From: Sarah Burrow <Sarah.Burrow@arun.gov.uk>
Sent: 01 July 2021 16:49
To: Planning.Responses <Planning.Responses@arun.gov.uk>
Cc: Finlay Gardner <Finlay.Gardner@arun.gov.uk>
Subject: RE: Planning Consultation on: Y/68/21/HH

Engineers Comments Regarding Surface Water Drainage

Application No: Y/68/21/HH
Registered: 24th May 2021
Site Address: 26 Canal Road Yapton BN18 0HD
Grid Reference: 497740 102968
Description of Works: Erection of single storey rear and side extension following the demolition of existing conservatory

FOR MR C. POOLE		
SITE 26 CANAL ROAD, YAPTON, WEST SUSSEX. BN18 0HD		
TITLE PROPOSED EXTENSION & ALTERATIONS BLOCK PLAN		
SCALE 1:500 © A3	DRAWN AH 05/21	DRAWING NO. 01B REV. A

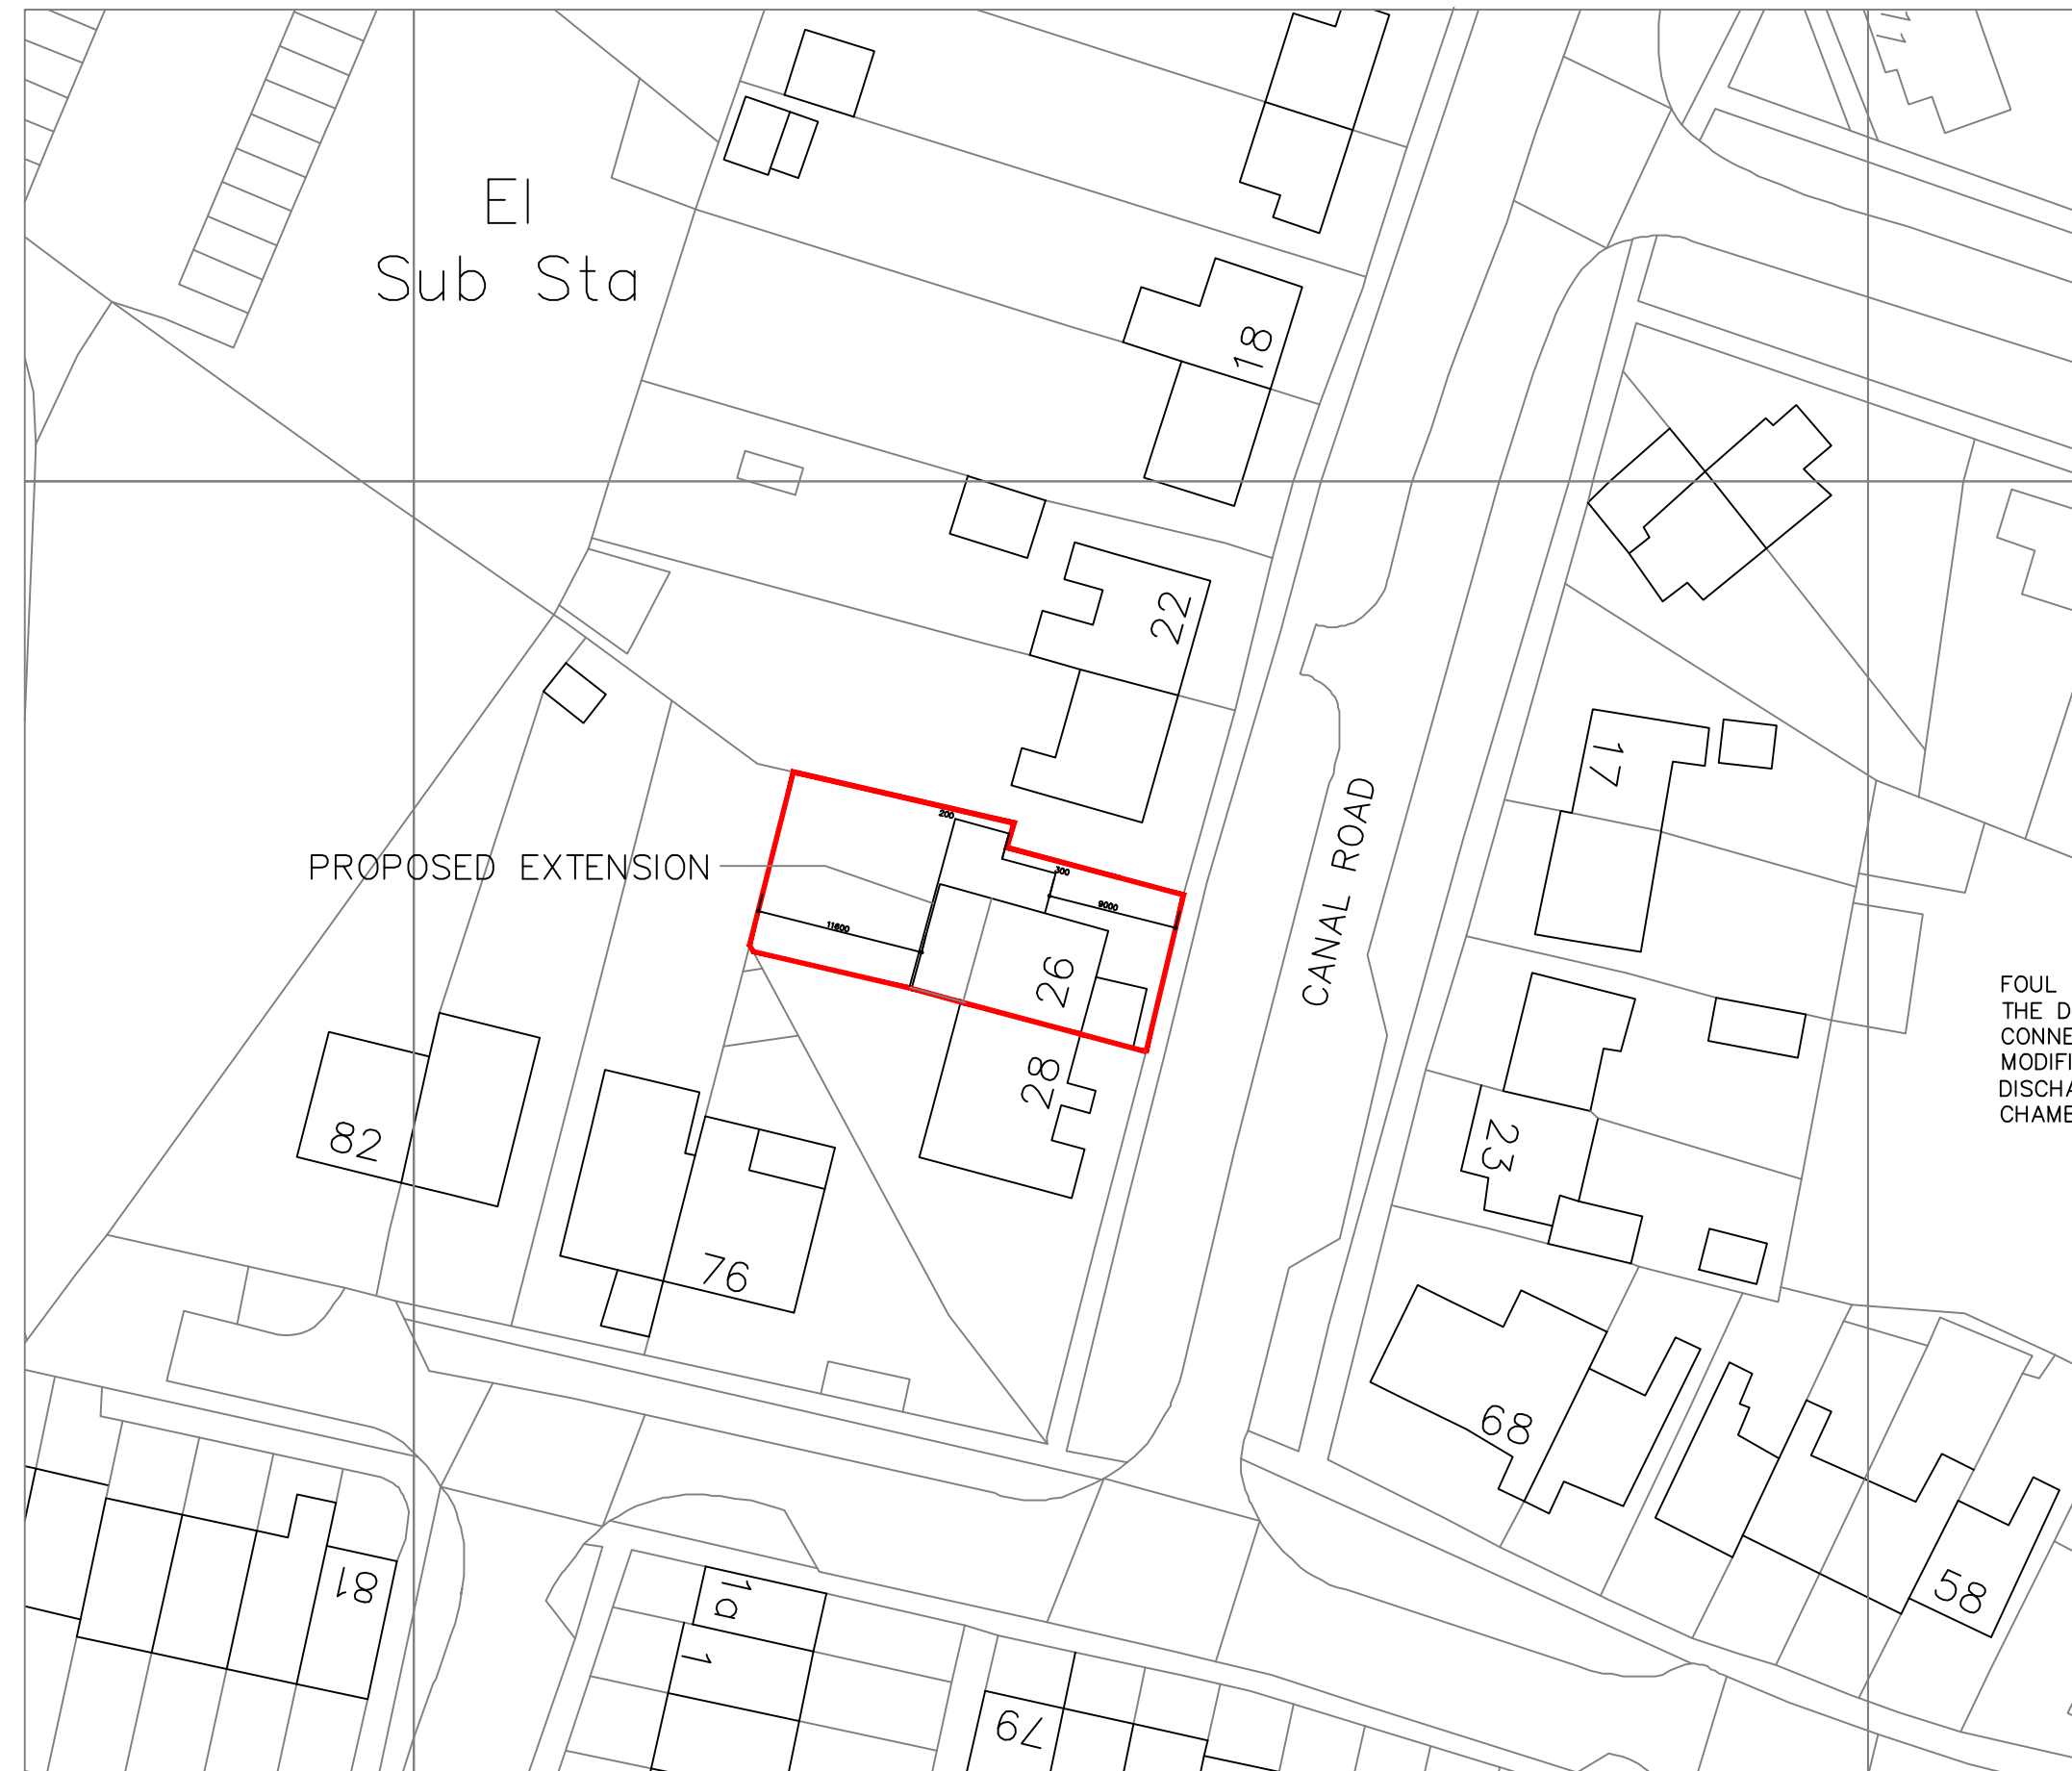
The application is within the Lidsey Treatment Catchment, therefore surface water drainage design should be carefully considered. Infiltration must be fully investigated.

In addition, our records show that there may be a public foul water sewer running through the rear garden of 26 Canal Road in close proximity to the proposed extension, **please consult Southern Water** for more detail and their required easements from this sewer.

"Development shall not commence, other than works of site survey and investigation, until full details of the proposed surface water drainage scheme have been submitted to and approved in writing by the Local Planning Authority. The design should follow the hierarchy of preference for different types of surface water drainage disposal systems as set out in Approved Document H of the Building Regulations, and the recommendations of the SuDS Manual produced by CIRIA. Winter groundwater monitoring to establish highest annual ground water levels and winter Percolation testing to BRE 365, or similar approved, will be required to support the design of any Infiltration drainage. No building / No part of the extended building shall be occupied until the complete surface water drainage
